Developer Services  
Southern Water  
Sparrowgrove House  
Sparrowgrove  
Otterbourne  
Hampshire  
SO21 2SW

12/10/2016

**Proposal: 95 No. dwellings together with access, landscaping open space & associated works.**

**Site: Angels Nursery, Yapton Road, Barnham, PO22 0AY.**  
**BN/43/16/PL**

| TITLE:   | OUTLINE SURFACE WATER DRAINAGE STRATEGY |

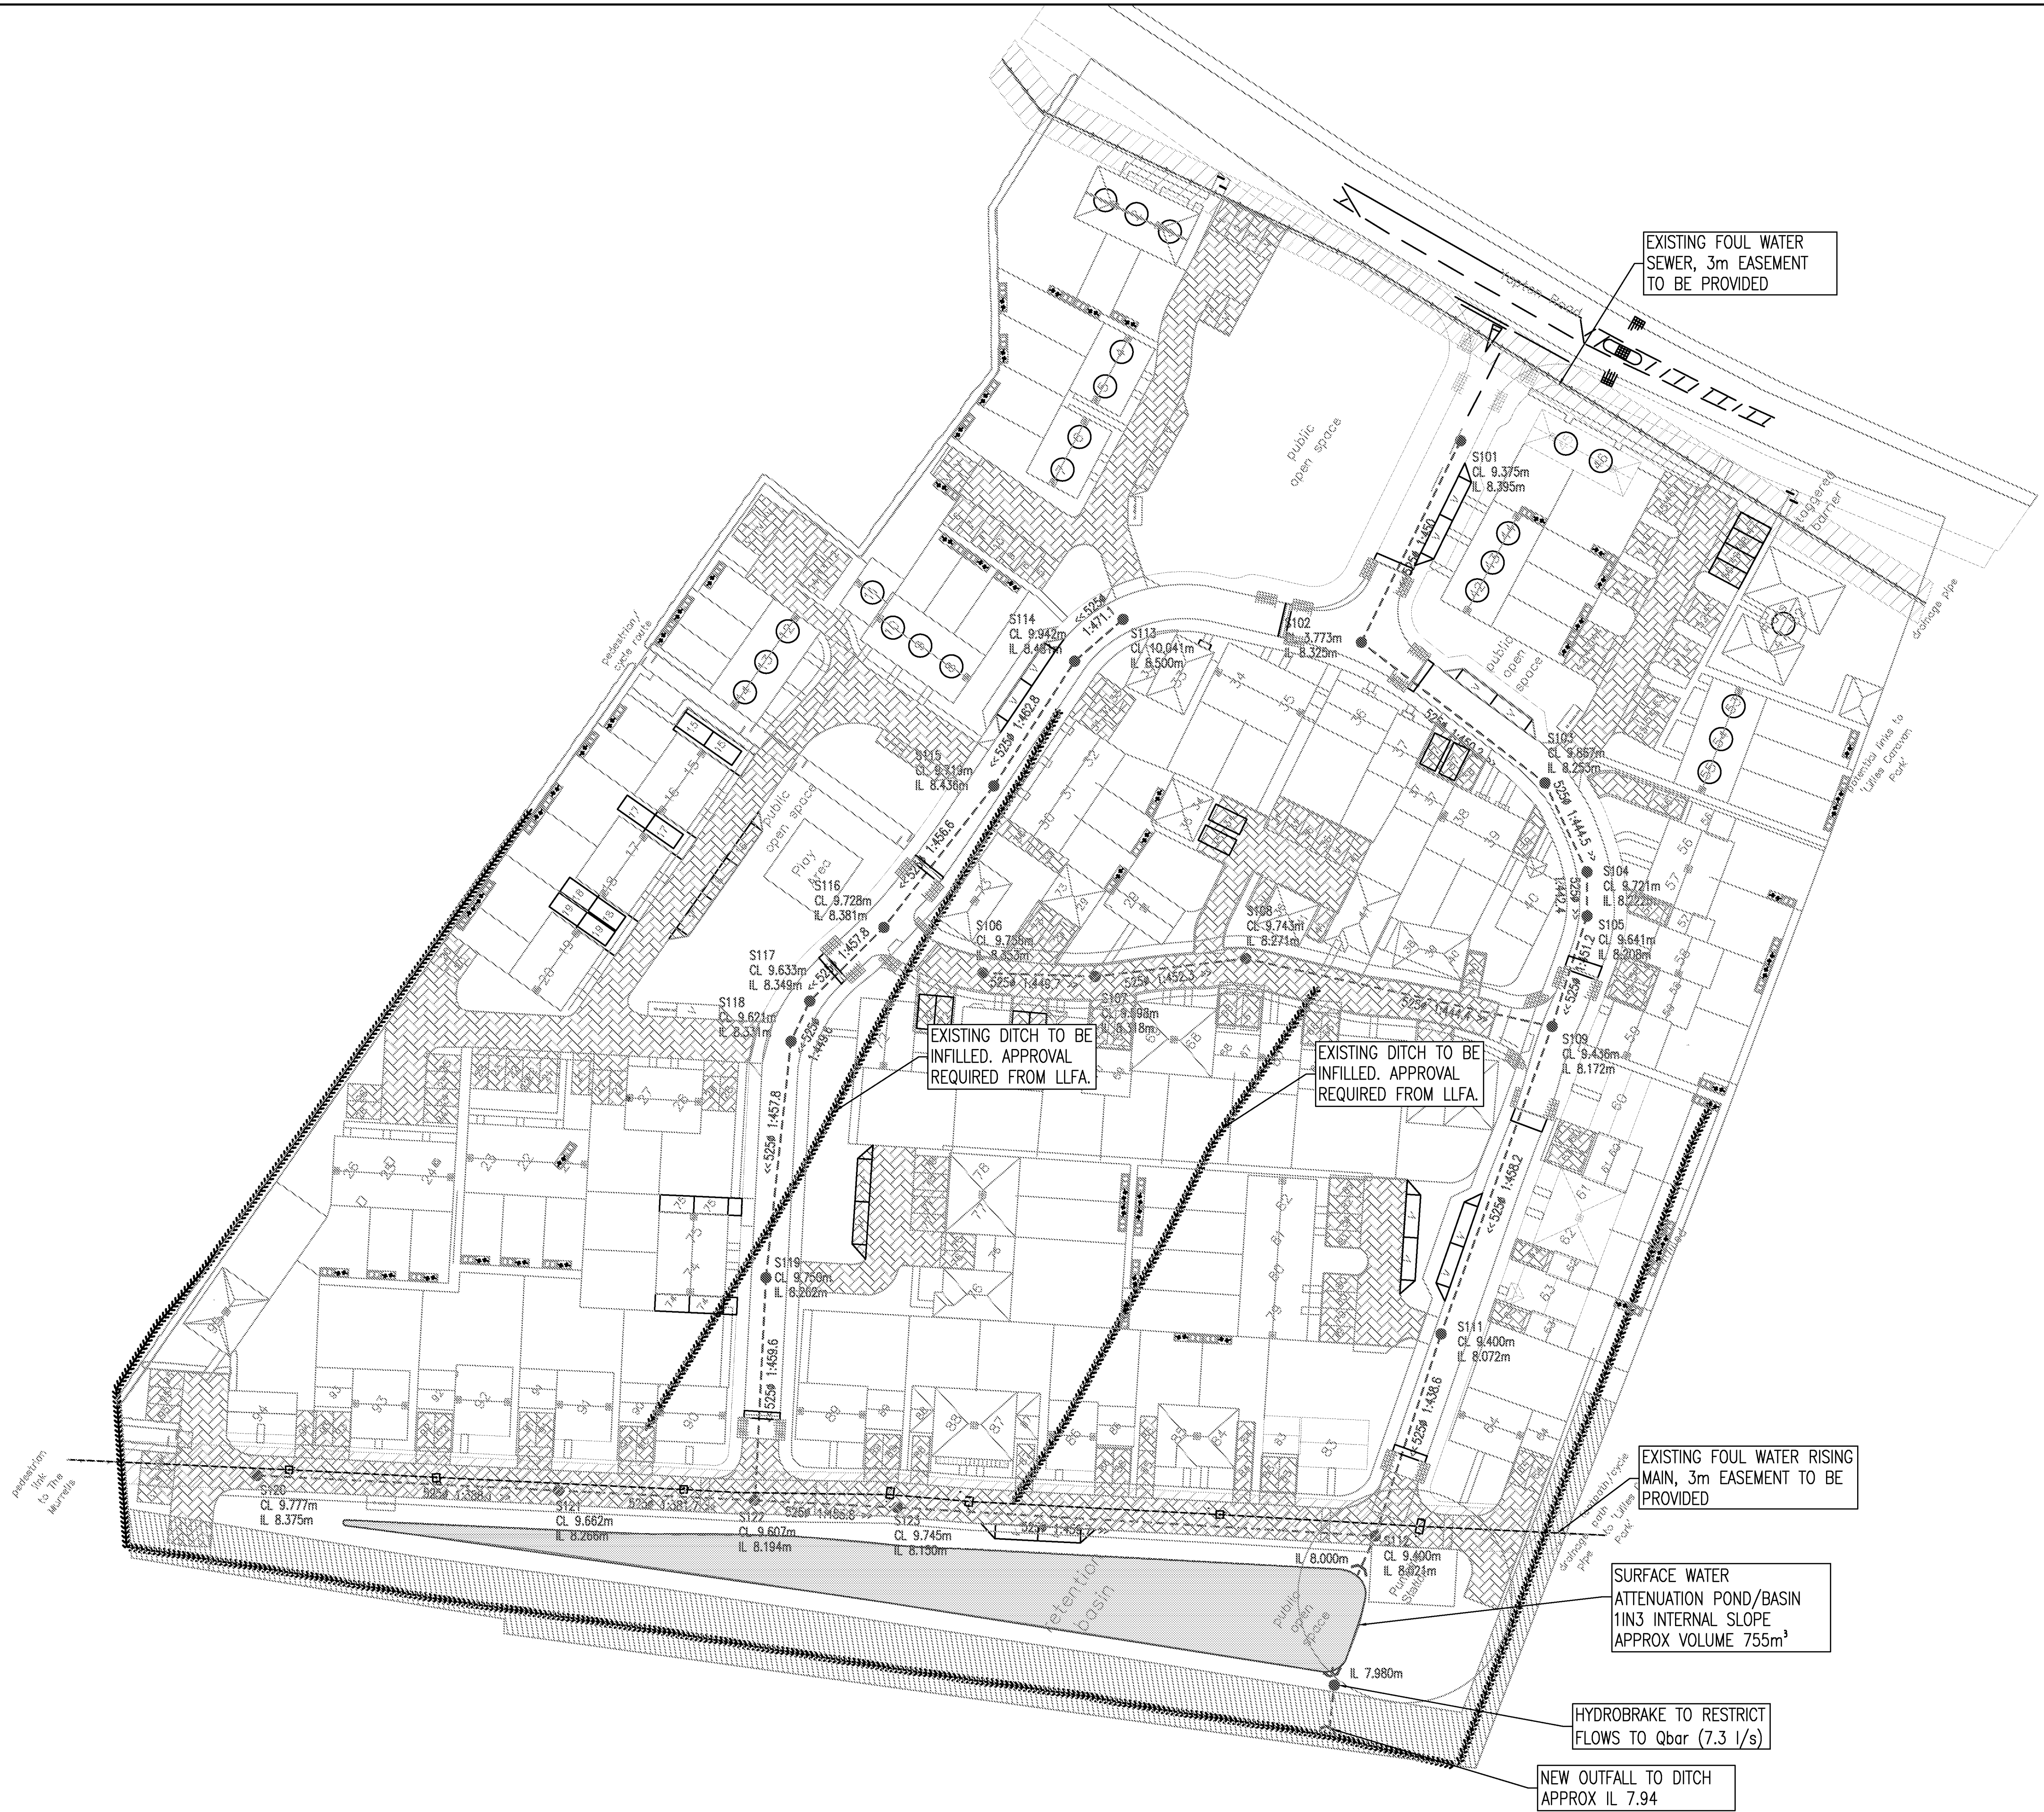
The planning application form makes reference to drainage using Sustainable Urban Drainage Systems (SUDS).

Under current legislation and guidance SUDS rely upon facilities which are not adoptable by sewerage undertakers. Therefore, the applicant will need to ensure that arrangements exist for the long term maintenance of the SUDS facilities. It is critical that the effectiveness of these systems is maintained in perpetuity. Good management will avoid flooding from the proposed surface water system, which may result in the inundation of the foul sewerage system. Thus, where a SUDS scheme is to be implemented, the drainage details submitted to the Local Planning Authority should:

The design of drainage should ensure that no groundwater or land drainage is to enter public sewers. Please note that construction of permeable paving over adoptable sewer will not be acceptable to Southern Water.

No new soakaways, swales, ponds, watercourses or any other surface water retaining or conveying features should be located within 5 metres of a public or adoptable gravity sewer, rising main or water main.
